**WEST SUSSEX COUNTY COUNCIL
STRATEGIC PLANNING CONSULTATION**

SUBJECT: P/76/16/PL - Construction of a building for the packaging, preparation & distribution of fresh foods with ancillary accommodation associated with the existing horticultural business, revisions to internal access road, car parking & hardstanding areas & landscaping & provision of a wetland. This application affects the setting of Listed Buildings.

LOCATION: Sefter Farm, Pagham Road, Bognor Regis, West Sussex, PO21 3PX.

This is the third WSCC highways and transport response to the planning application. It follows assessment of additional information provided by the applicant's highway consultant in email – Bava Sathan (The Civil Engineering Practice) to Tim Townsend (WSCC Highway Authority) dated 1st November 2016.

Drawing: Reedbed layout & mitigation

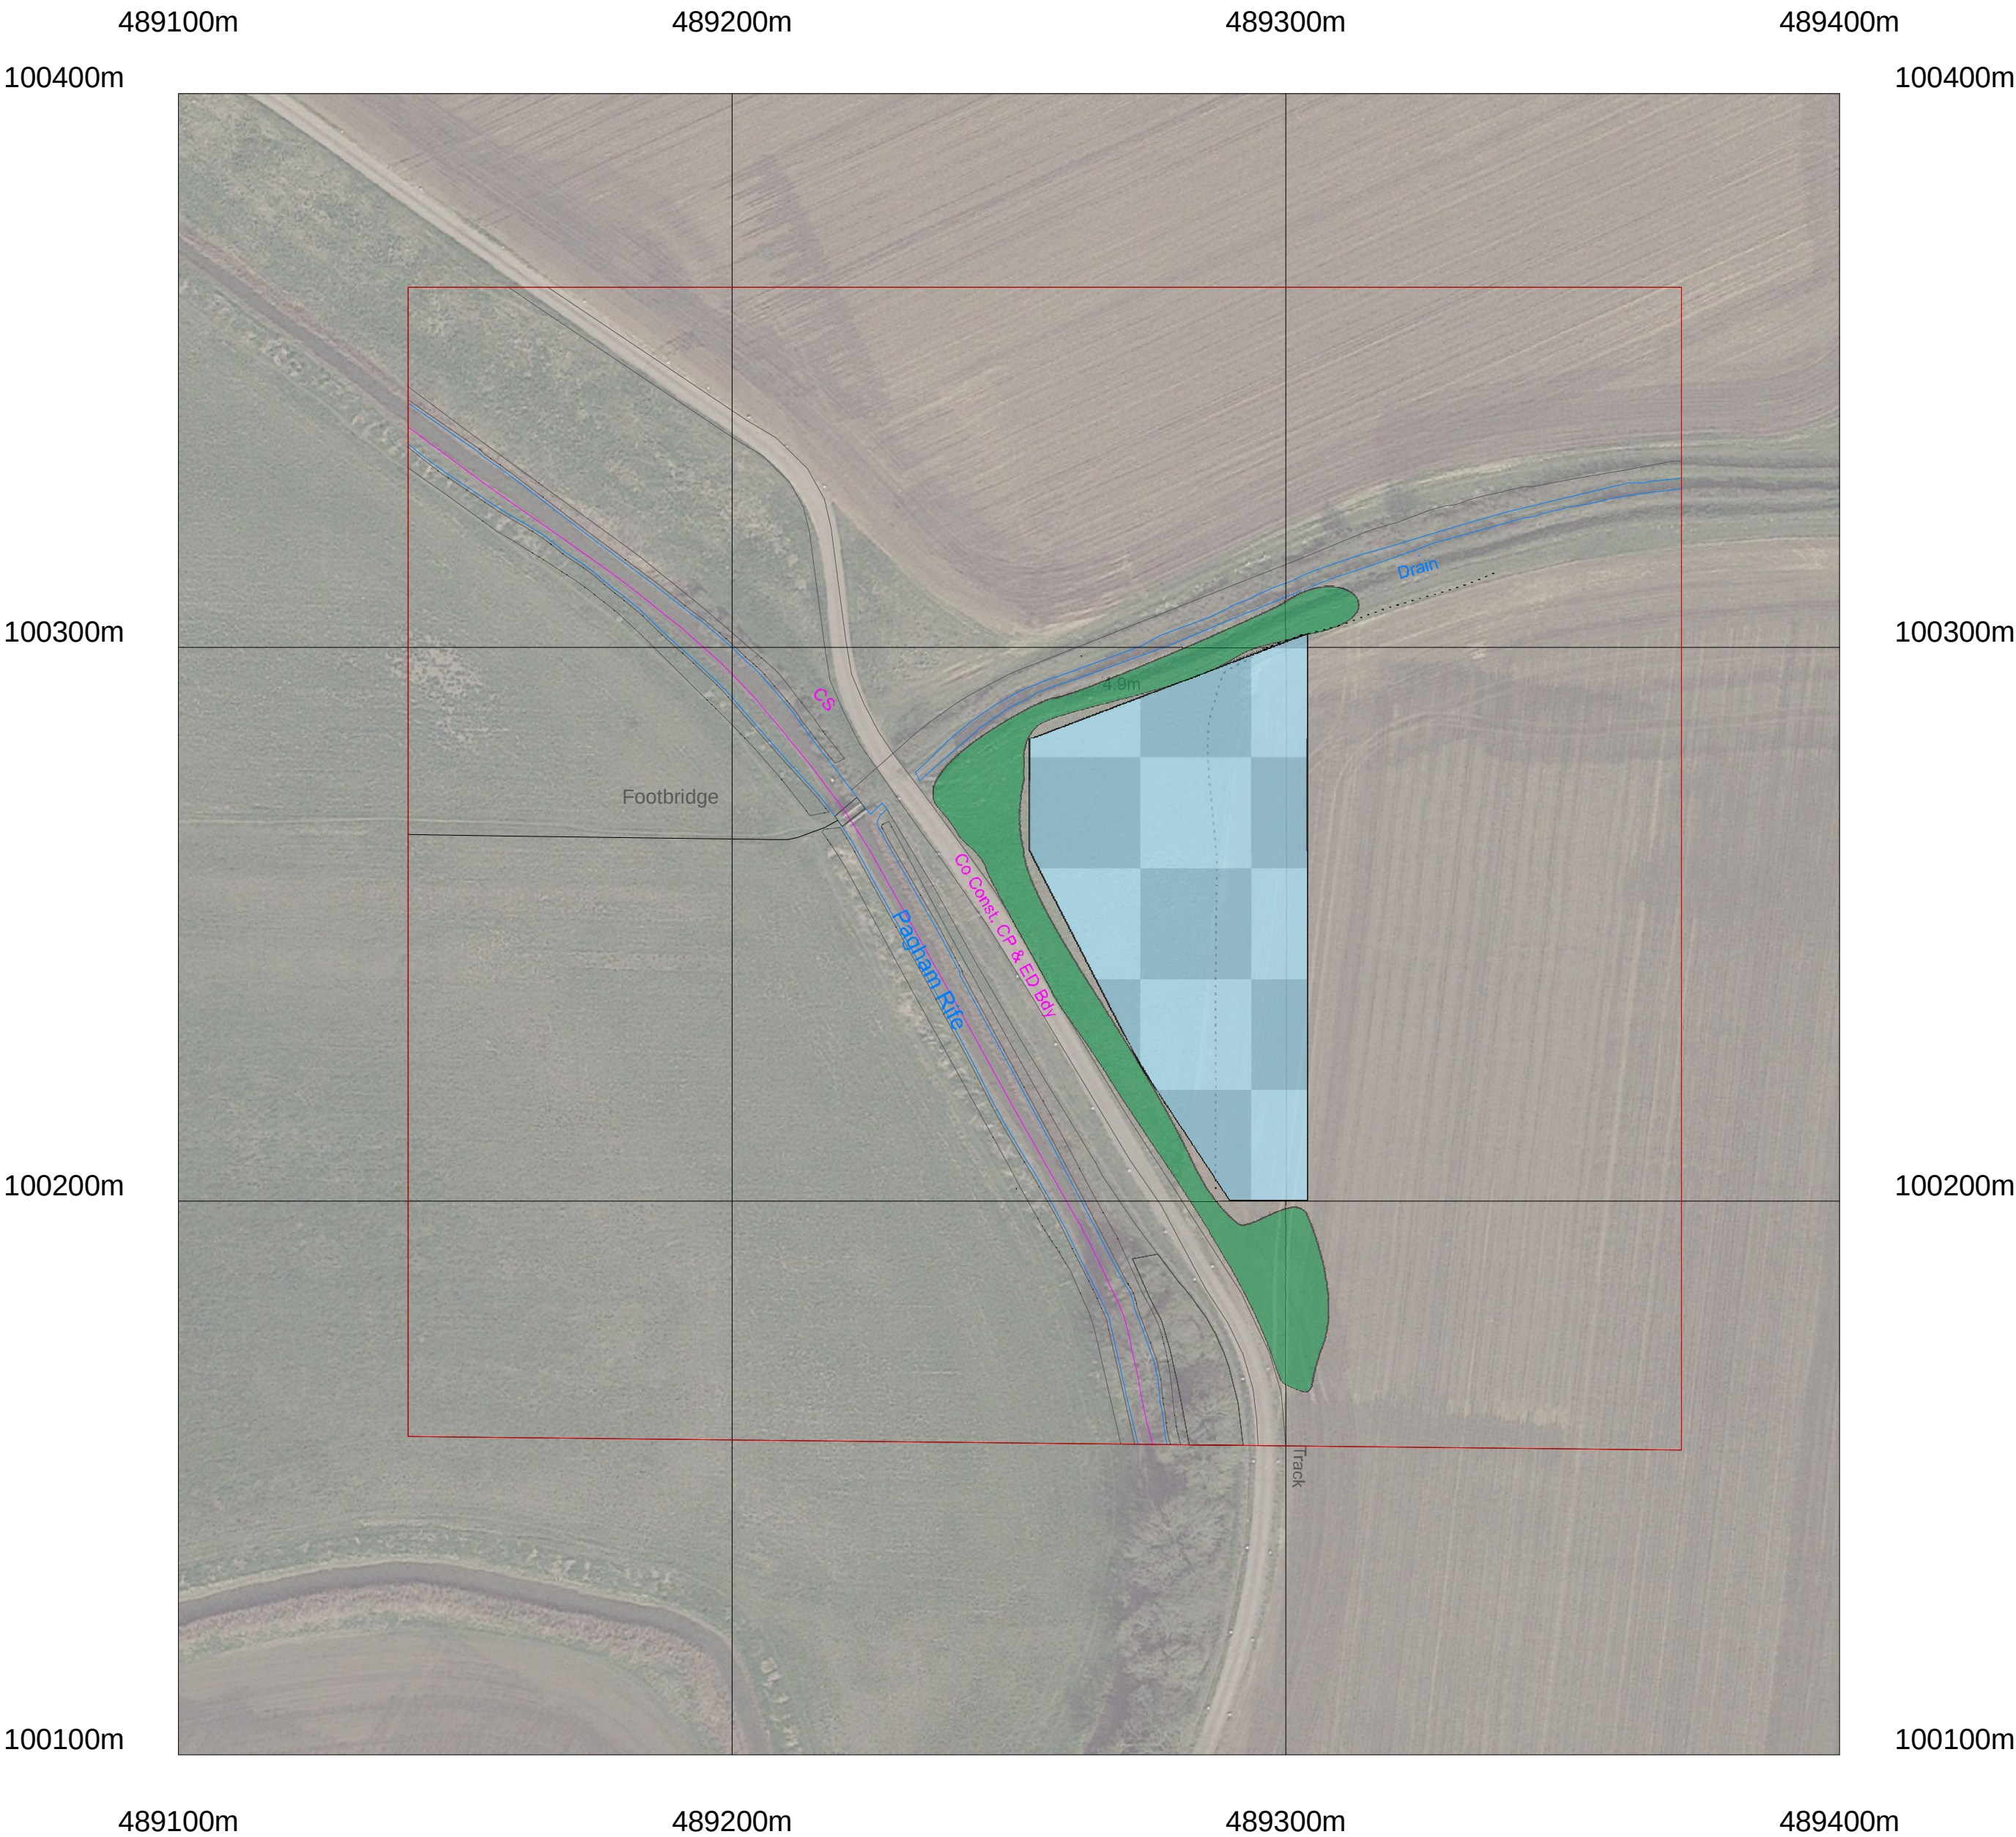
Whilst the main part of the application does not directly impact on the bridleway known as BW129, there is the reed bed and wetland mitigation which is very close to the southern boundary to the bridleway.

This particular area does get very wet especially during the winter months. The bridleway also drains downhill to this area (corner of the field to the Pagham Rife). The creation of the wetland area and reed bed could be of great benefit to hold water and provide good wildlife habitat, it also could improve the drainage in the area which would benefit the bridleway. Previously, comments from the PRoW officer said that before WSCC could offer support to this application, further clarification as to how the wetland area is to be constructed should be provided and if there is any opportunity to take some of the surface water from the bridleway into the wetland area to therefore improve the bridleway drainage at this point. WSCC would also ask for further assurances that this will not make the bridleway any wetter.

The applicant's has responded to this regarding the wetland area being a closed system. They are proposing a 10m margin between the wetland and the ditch on the southern boundary of the bridleway which WSCC PRoW team will accept on this occasion. The PRoW team is also happy with the assurance that the bridleway drainage will not be affected by the wetland system. In any event, if there is any problem with the drainage from the wetland to the bridleway going into the future this will be covered by legislation.
